Your Ref: OWPC16550
Our Ref: A/190/17/HH 17-10-2017
Please ask for:
Mrs A Gardner

Erection of single storey detached double garage
Harcourt West Drive Angmering

DRAWING	PROPOSED SITE PLAN AND ELEVATIONS																						
Date	October 2017	Drawn By	PJC																				
Scale	1: 200 - 100 @A3	Iss. App. By	DKC

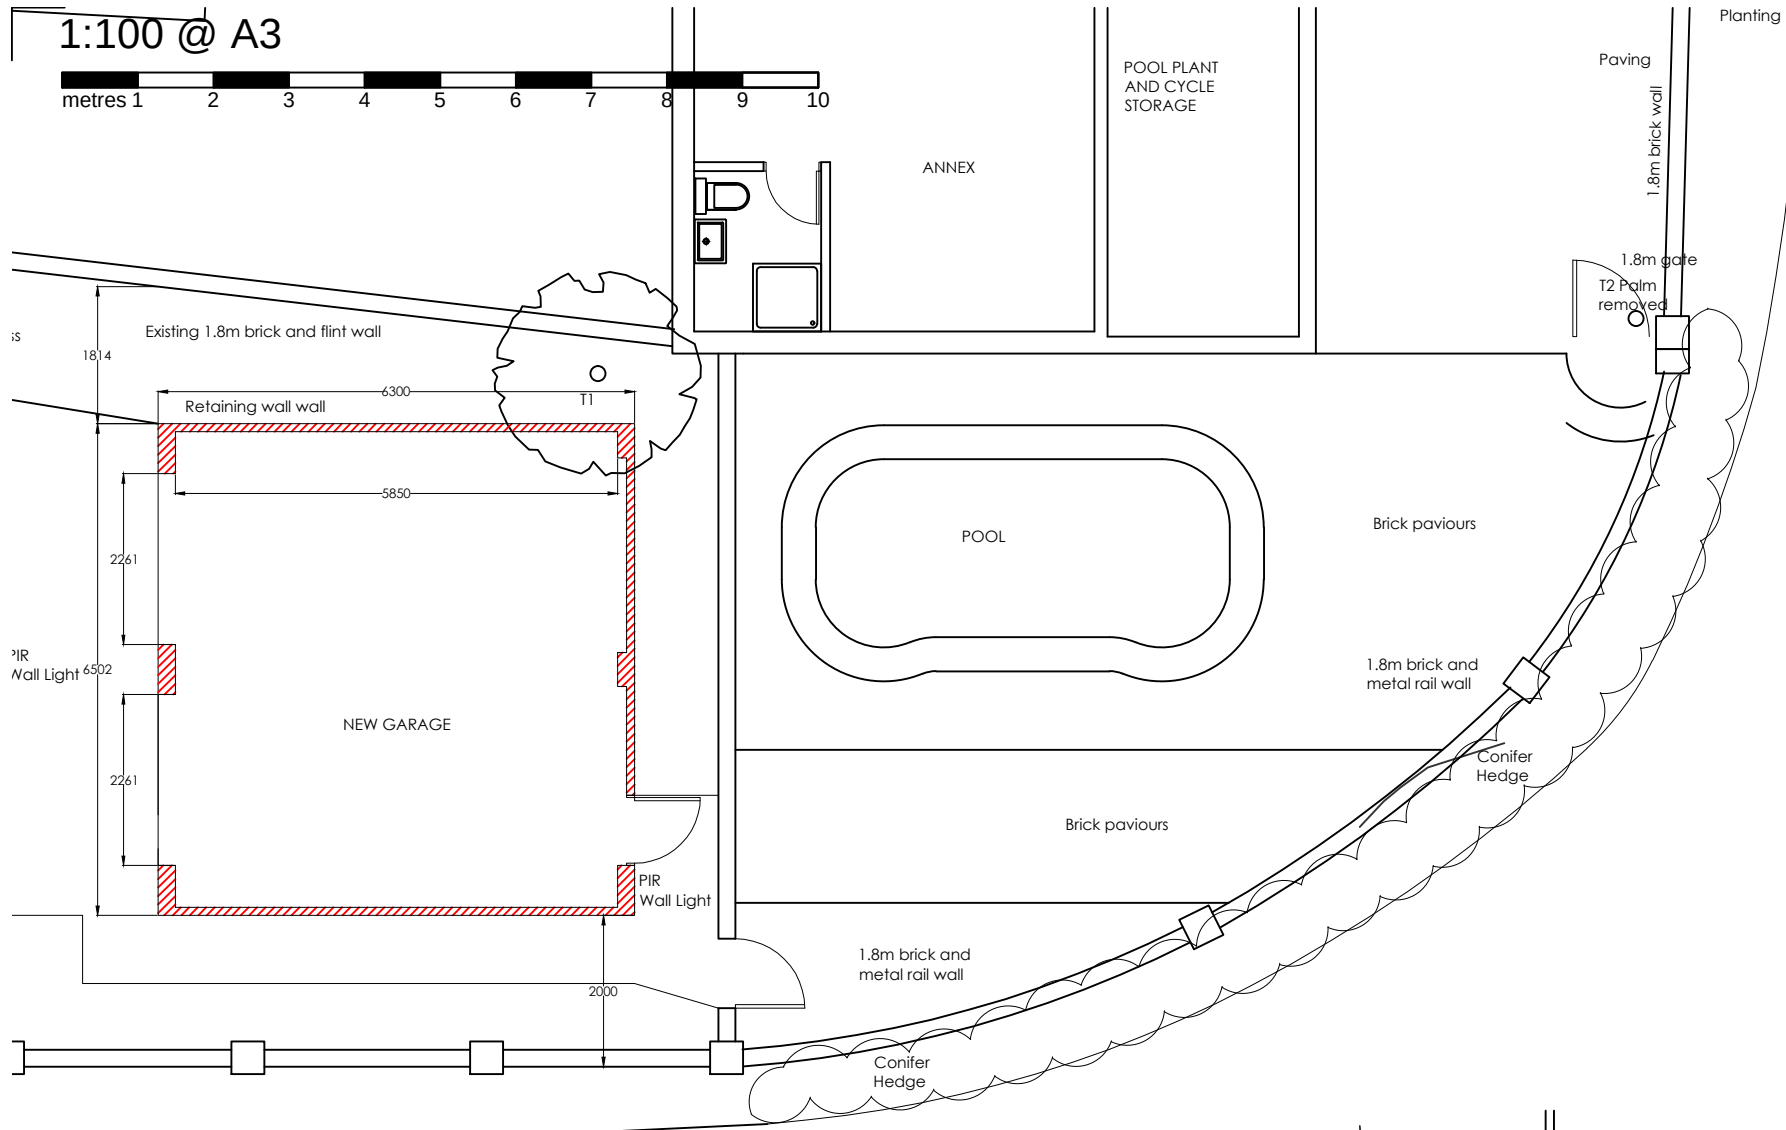
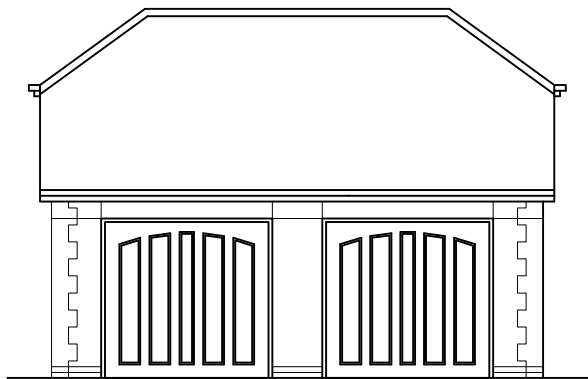
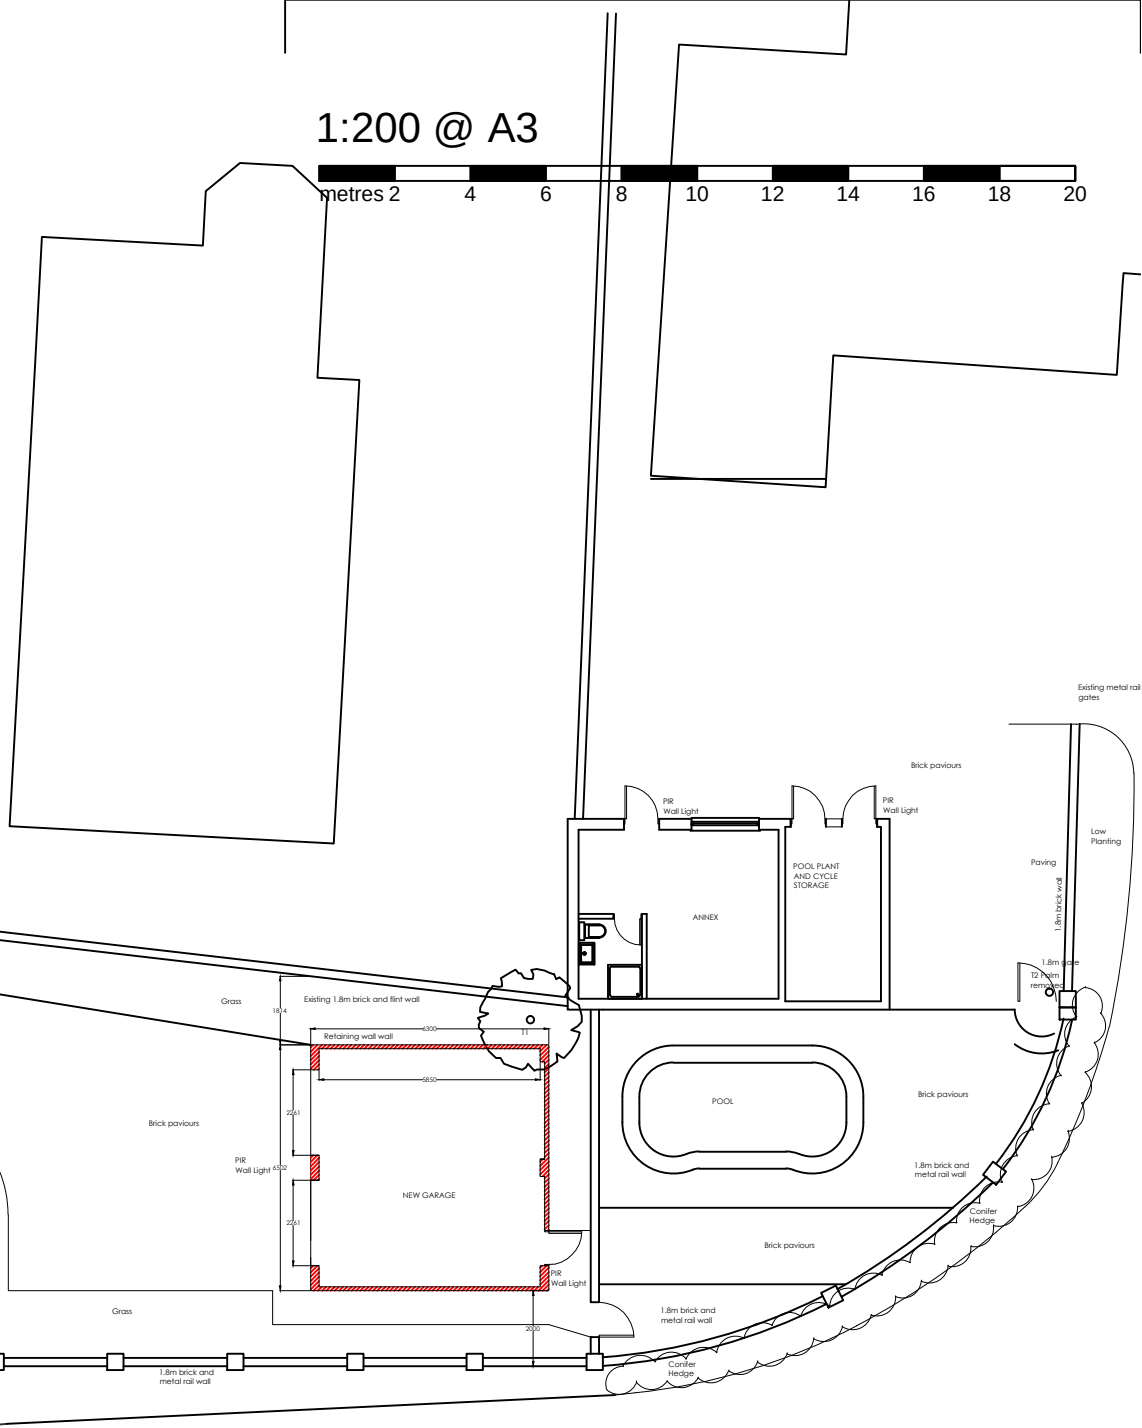
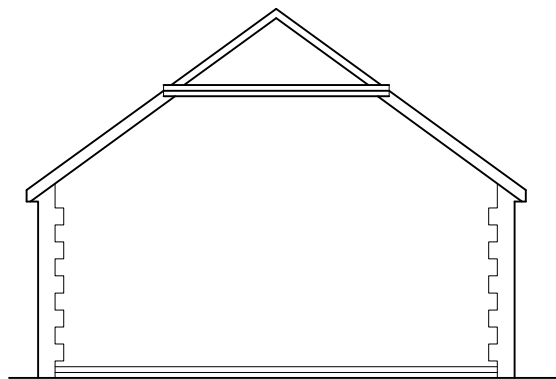
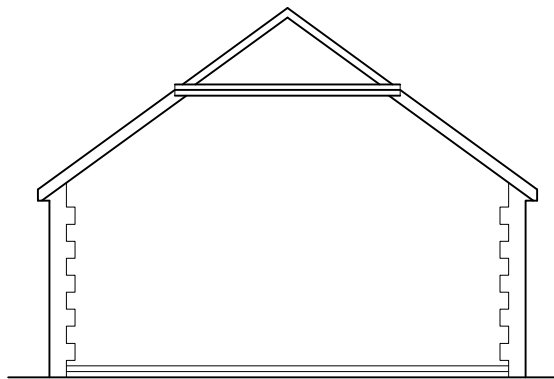
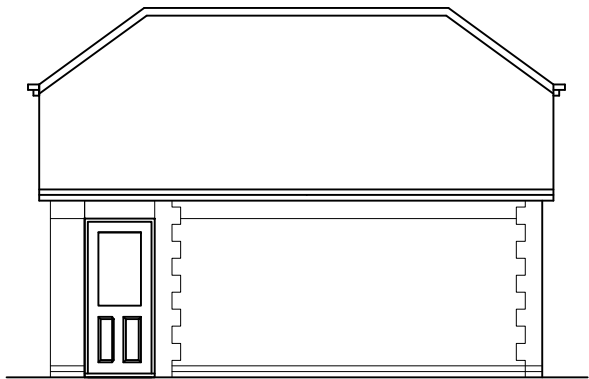
- 1) Location and size, particularly height of the block, would be out of keeping with the area and will impact negatively on the area. Previous application for a building over the swimming pool (A/121/17/HH) was approved, when this building was deleted from the application on the basis that the height of the swimming pool structure was not obtrusive, and was eventually presented as a flat roof. Approval of this application would be contradictory to the previous approval.*

- 2) Building on this garden lot, which slopes sharply down to West Drive would increase the problem of surface water flooding in the roadway, which will impact surrounding properties as well as road users of all kinds (vehicle and pedestrians).*

- 3) The roadway is shared by car & service vehicles as well as pedestrians. Access from the land at the point proposed would add dramatically to the risk of collisions and injury to other road users.*
